Sent: 18 October 2017 16:52
To: Planning; Mark Jones
Subject: FP/193/17/HH - 5 Roundle Avenue

Proposed North Elevation

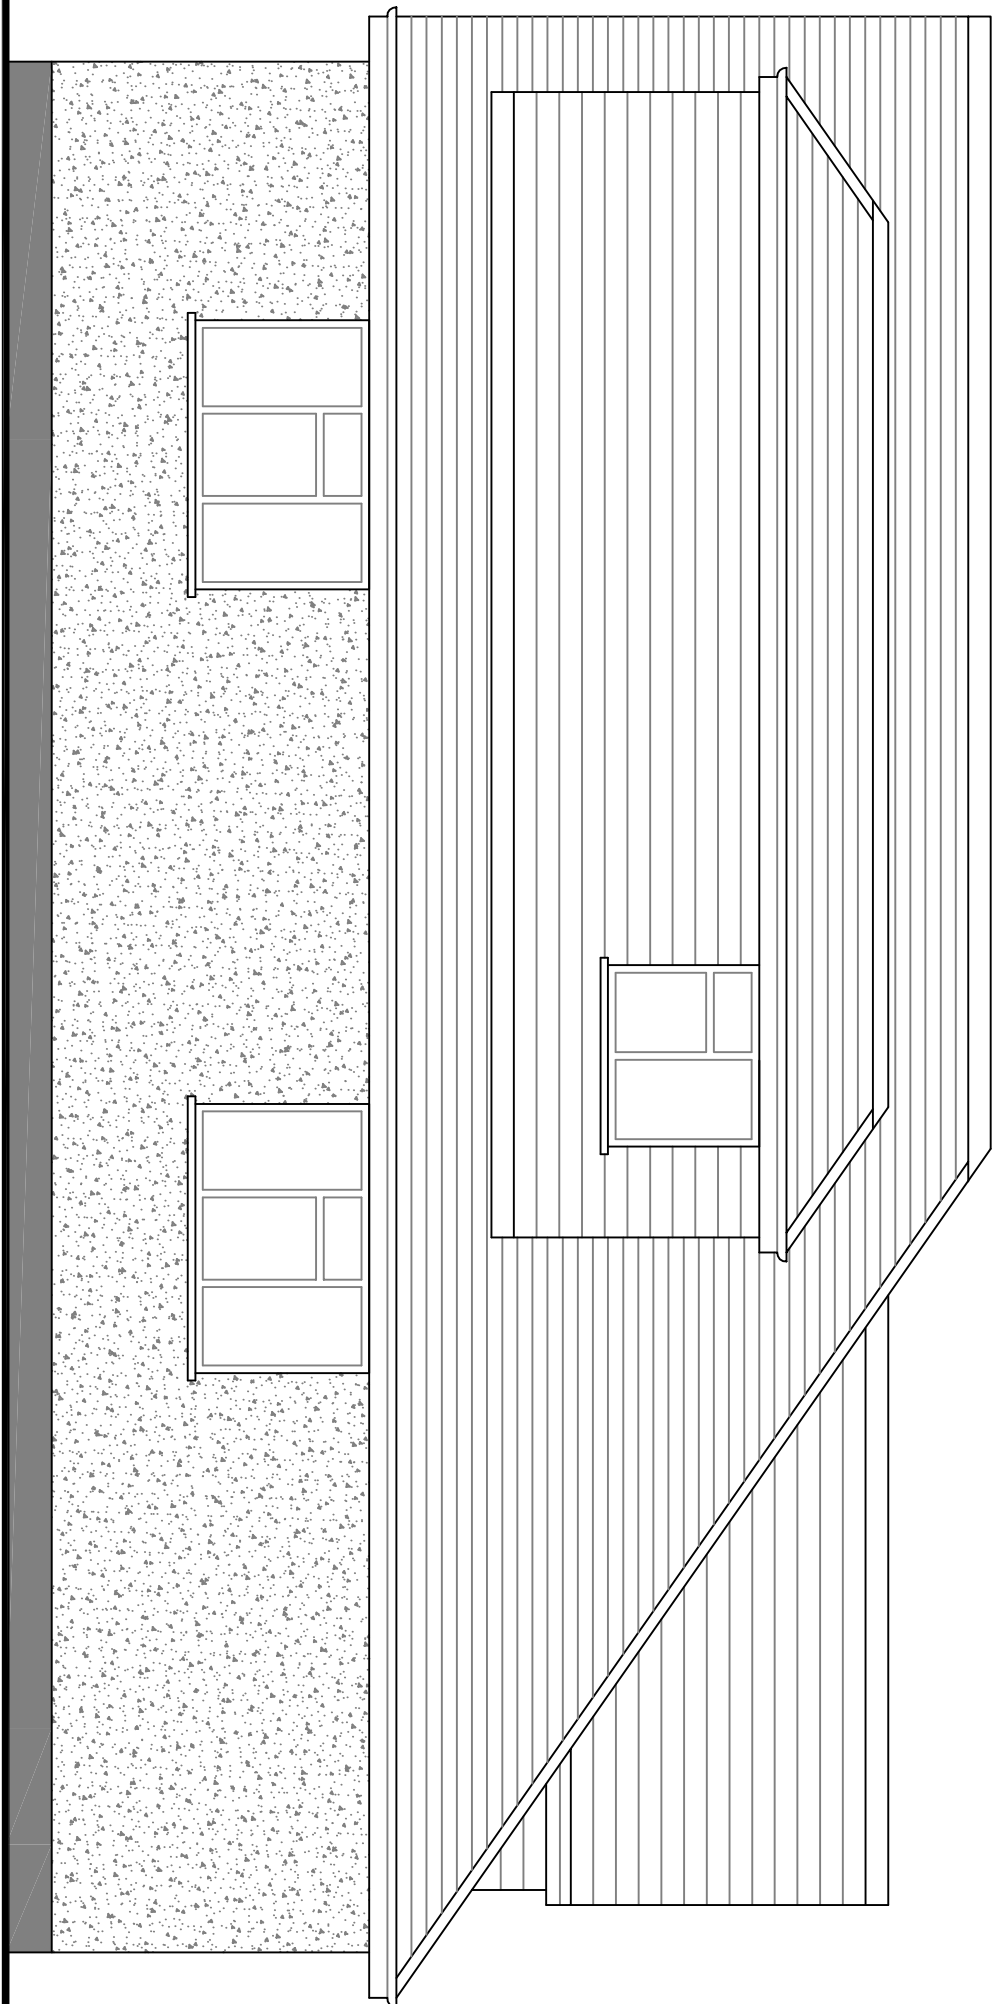
I urge you to take all matters into consideration when making a decision on this application – we did request the cill height measurements to the windows on the north elevation and this information has not been forthcoming – if this application goes through we have no right to object further.
